Subject Uniting Charlestown Development

27 Tiral Street, CHARLESTOWN NSW 2290

Thank you for the opportunity to comment on the proposed Uniting Charlestown seniors housing, residential flat building and subdivision development.

Drawing No. **L-100** Drawing Name **Landscape Masterplan Lower Ground Floor**

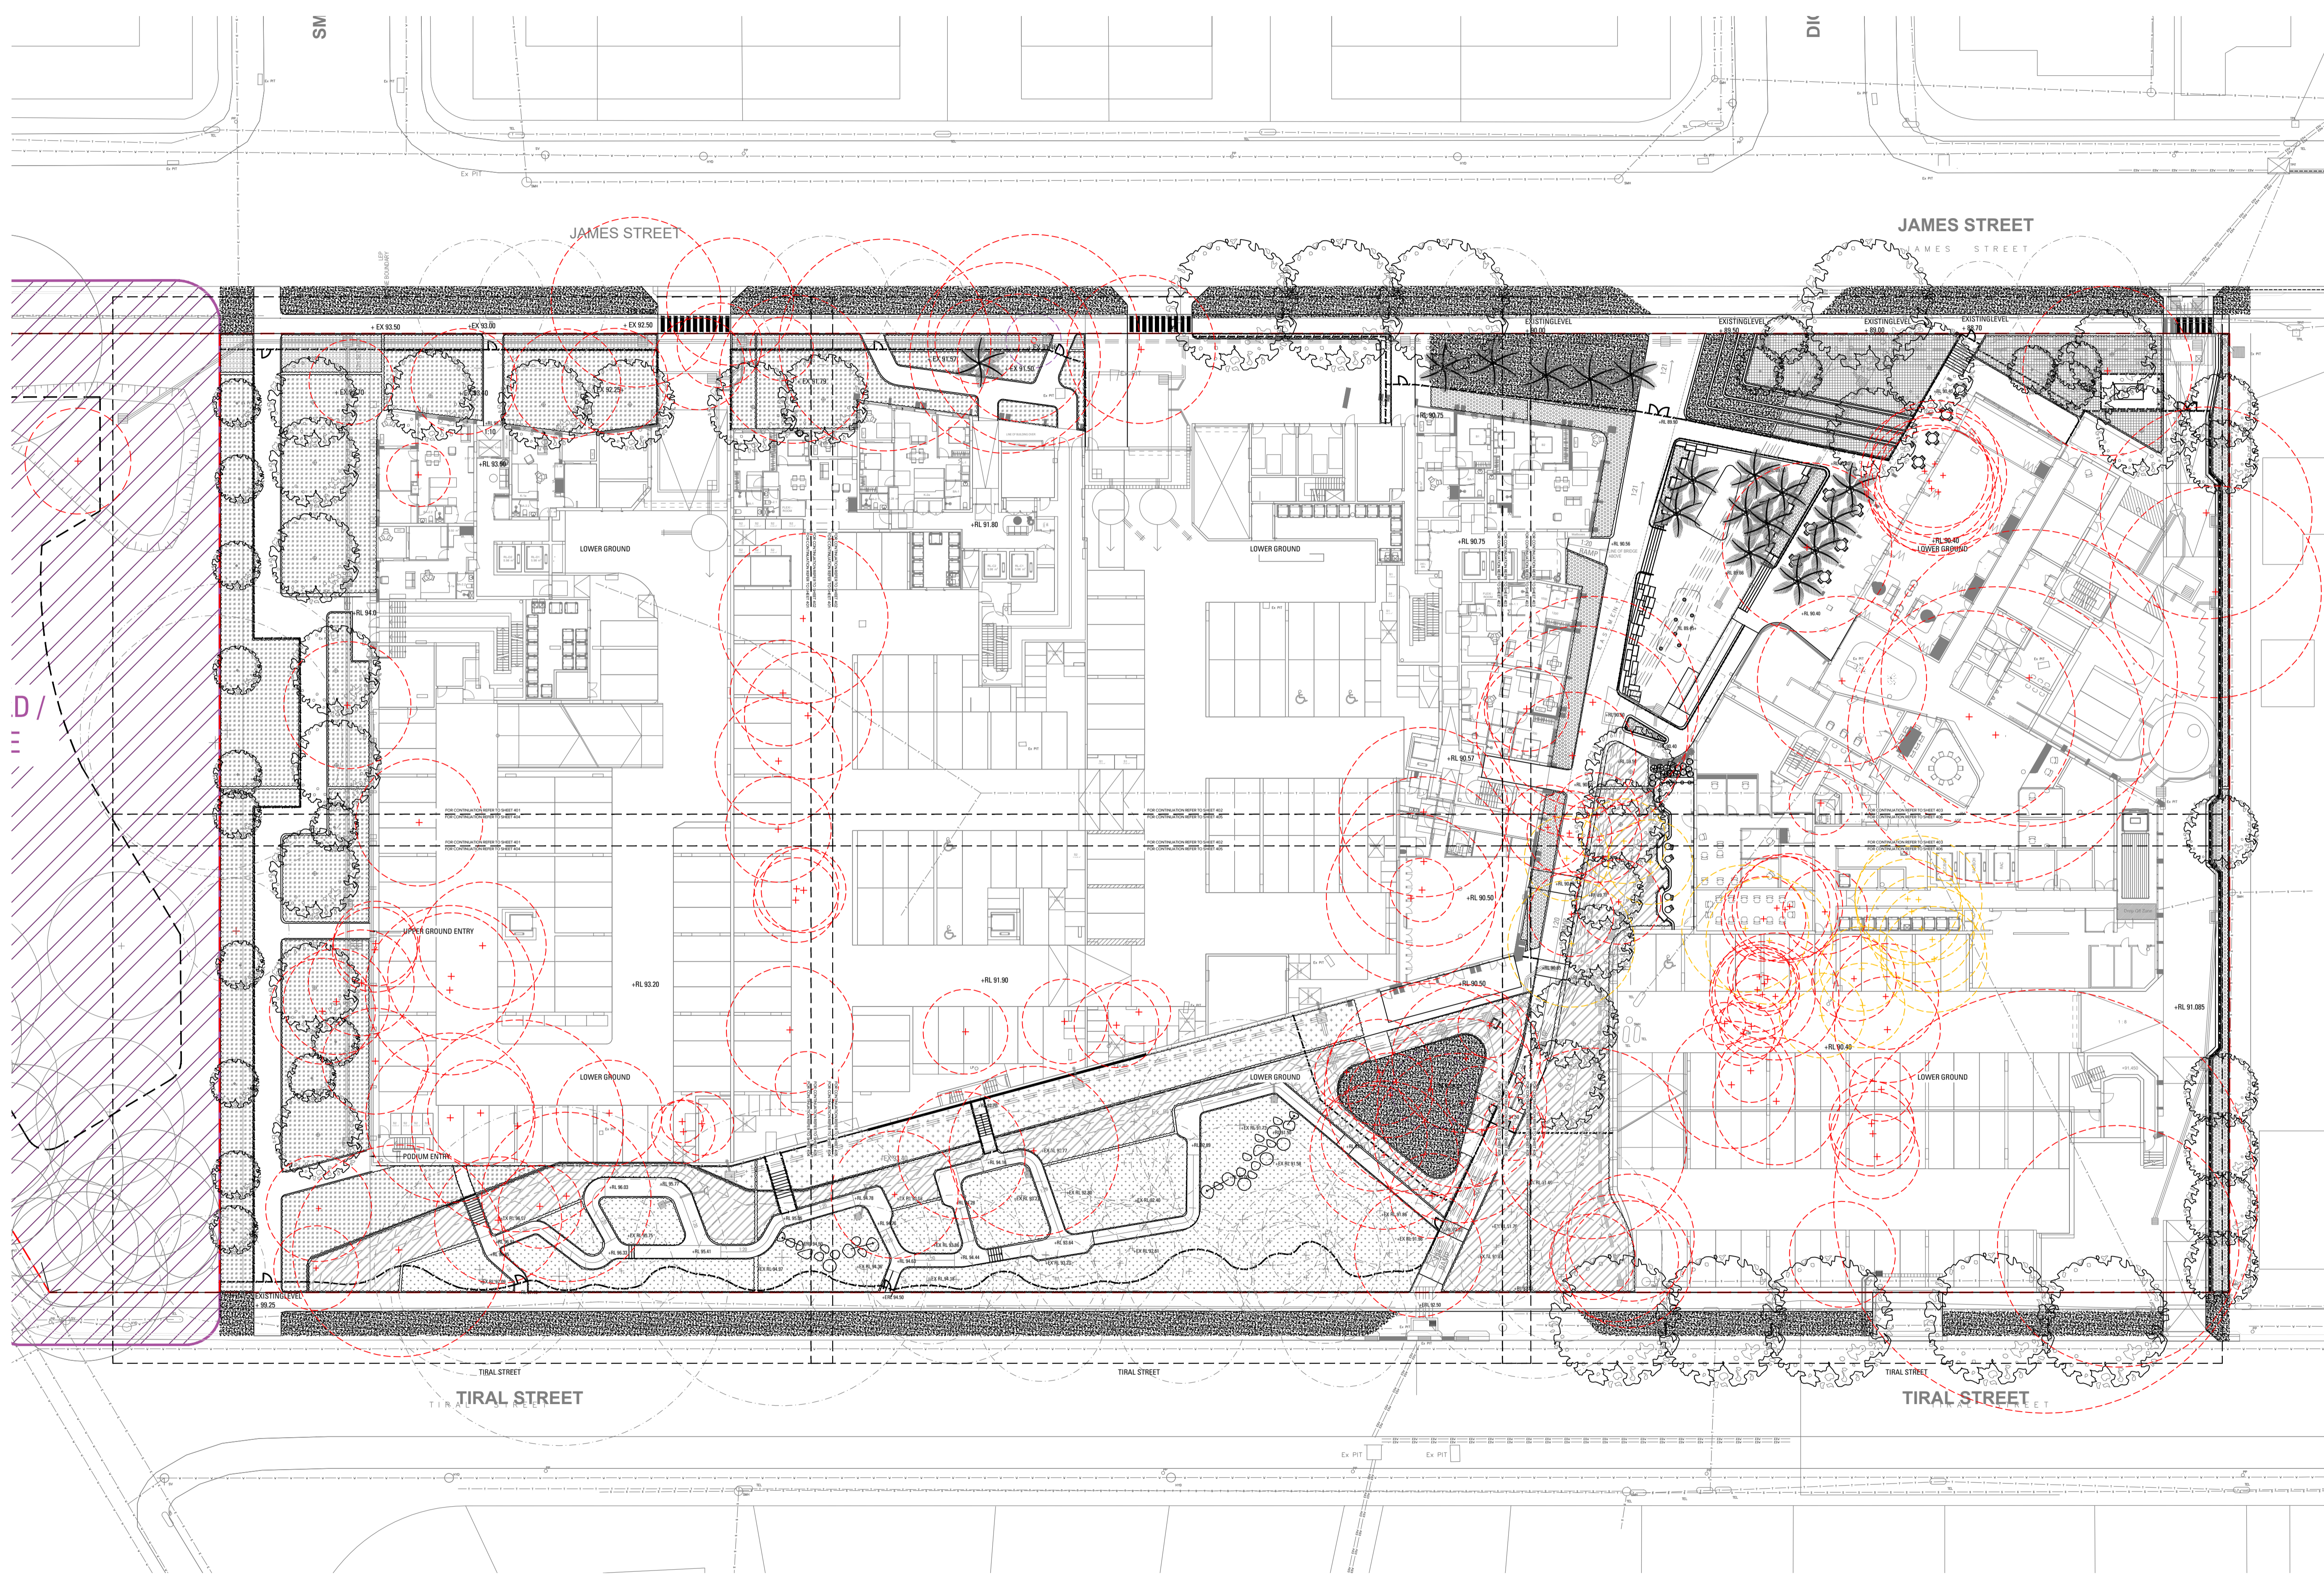
The large brick retaining walls along will provide a canvas for graffiti and provides an adverse visual impact to the streetscape. It is recommended to explore landscaping/green walls to reduce the risk of graffiti and to soften the hardscape features onto the streetscape.

Council's Natural Assets will support the removal of established street trees, pending the inclusion of compensatory street tree plantings in the landscape design plans. Revised landscape plans identifying the inclusion of street tree plantings along the road verge of all adjacent roads (James St, Tiral St & Dudley Road) is recommended.

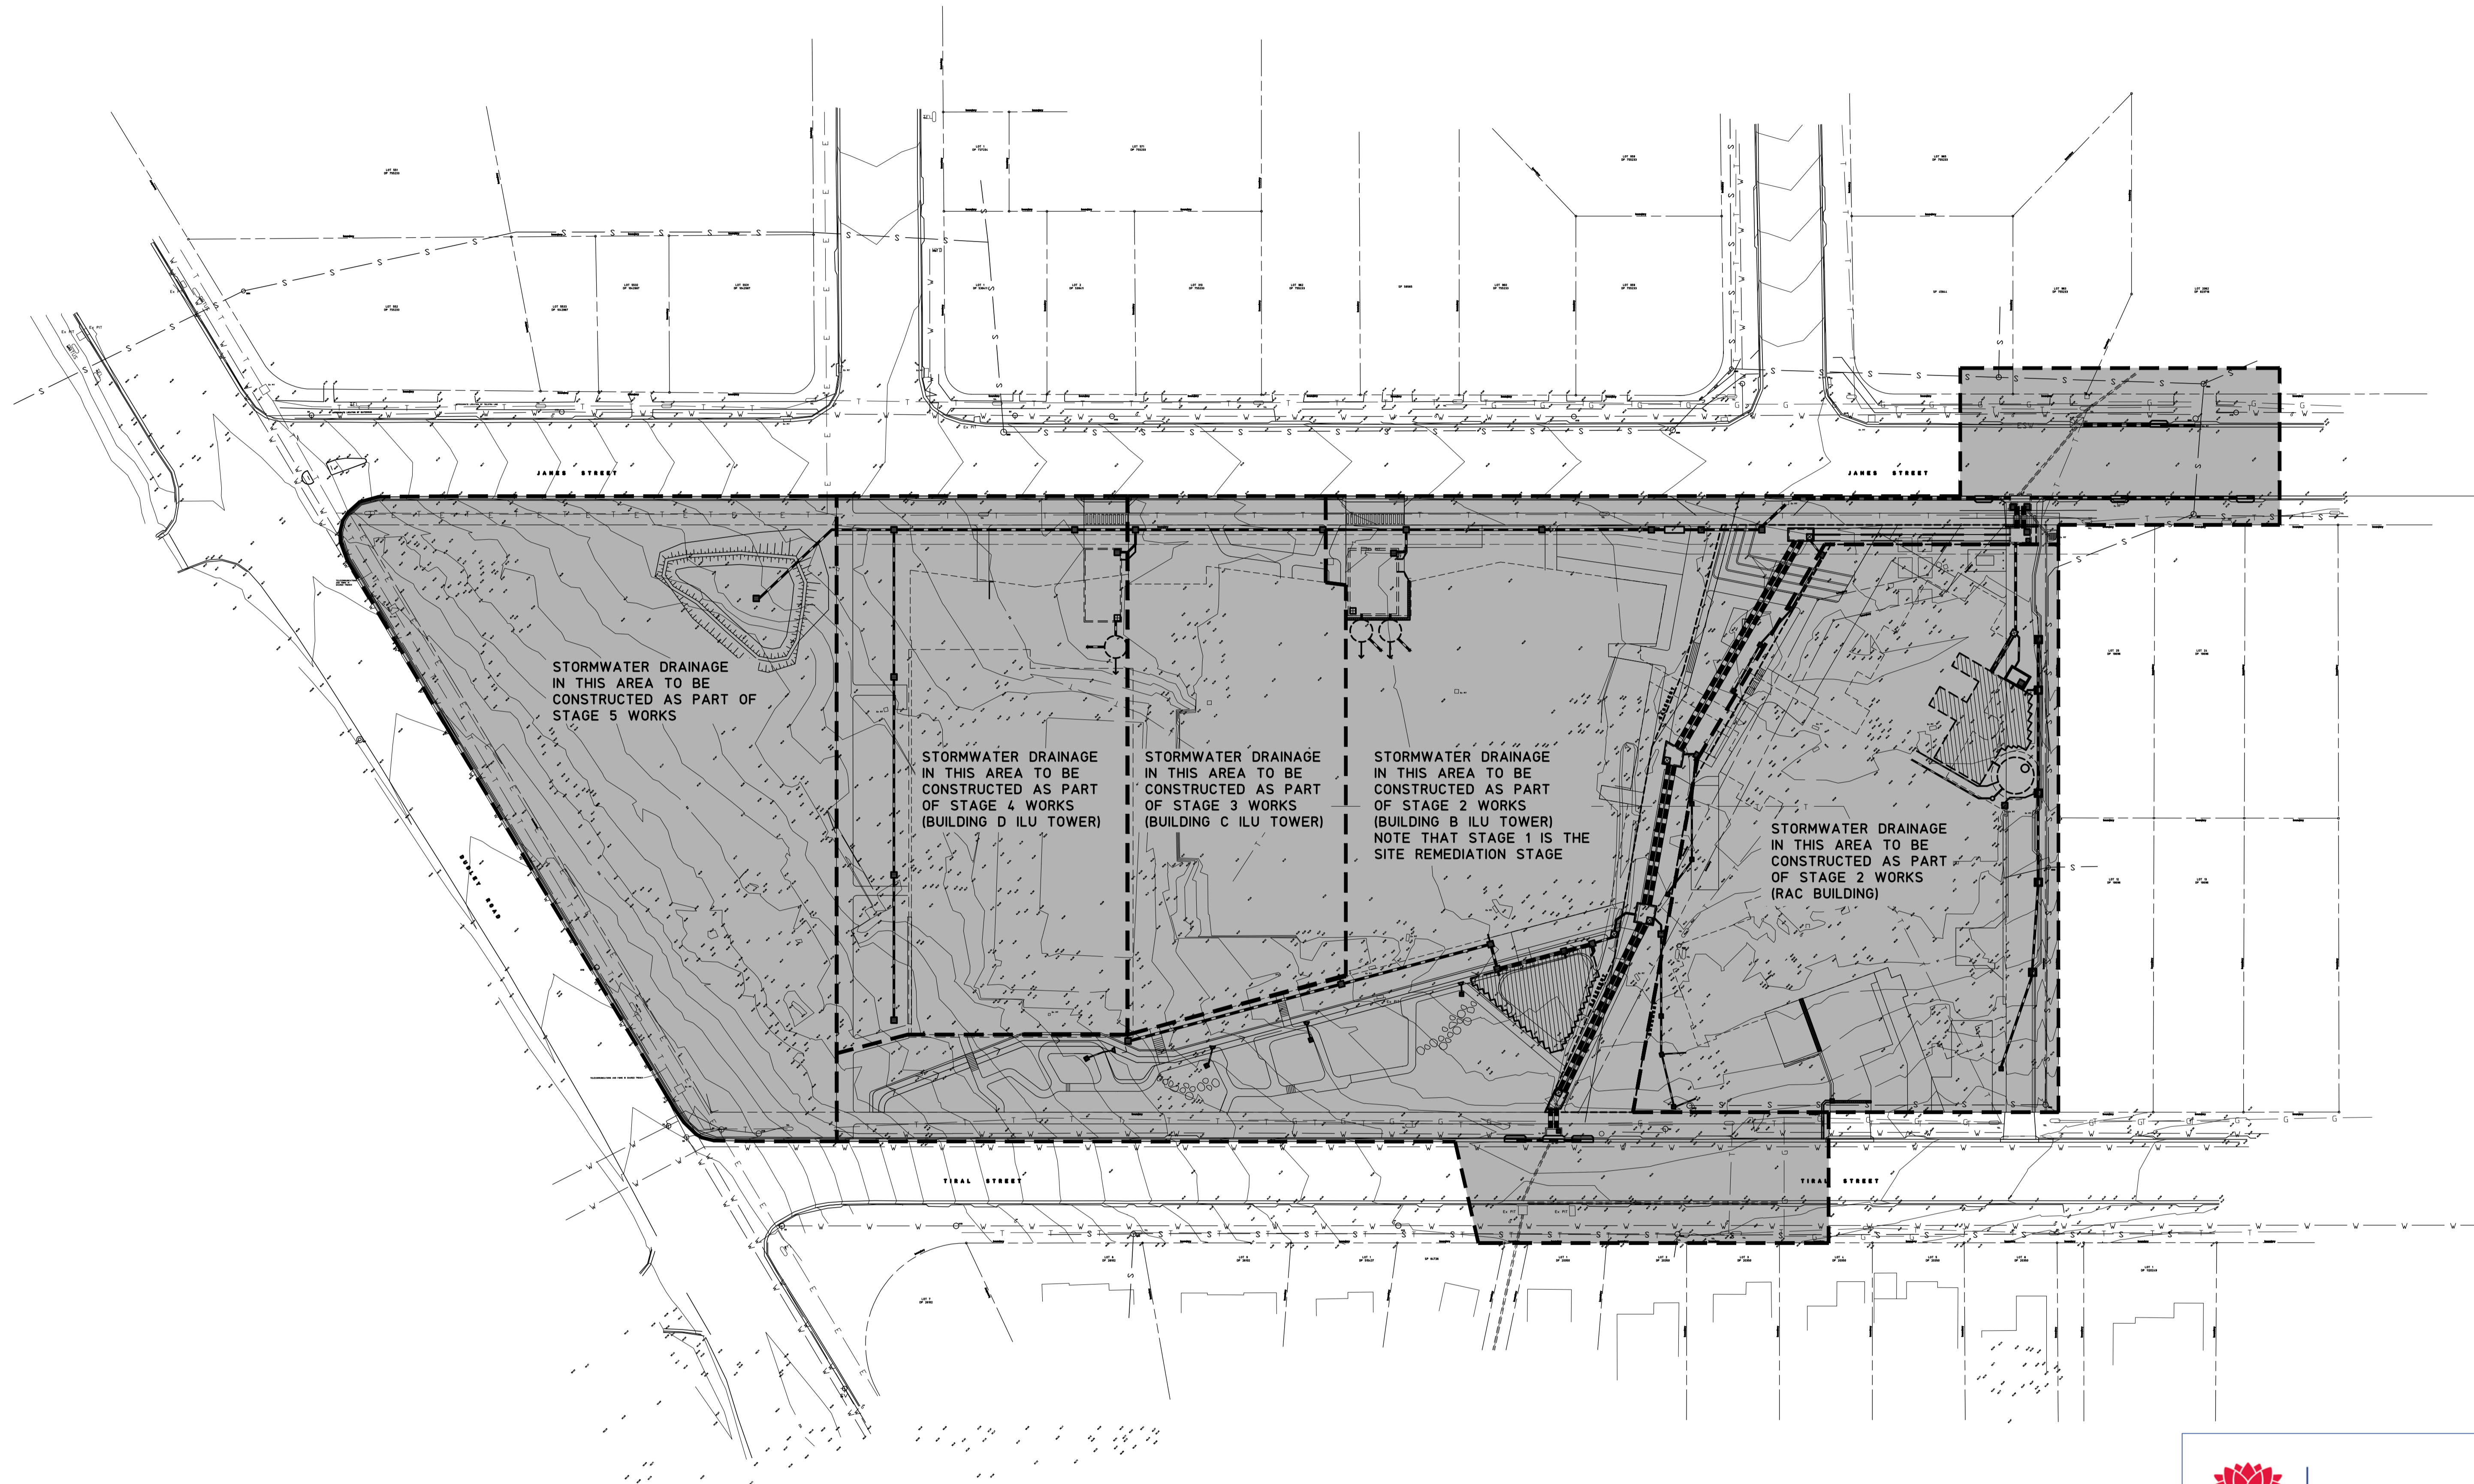
The proposal is shown constructing new drainage structures to convey public road water from Tiral Street to James Street via an underground and overland flow drainage system. These drainage structures are to be built within an easement in favour of Council. The new drainage structures and easement are influenced by building encroachments and multiple landscaping features that will need to be considered further. Concerns are raised by any overland flowing in conjunction with the pedestrian walkways across this easement. The stormwater management plan should address these encroachments.

These features will impose onerous maintenance and replacement responsibilities on Council.
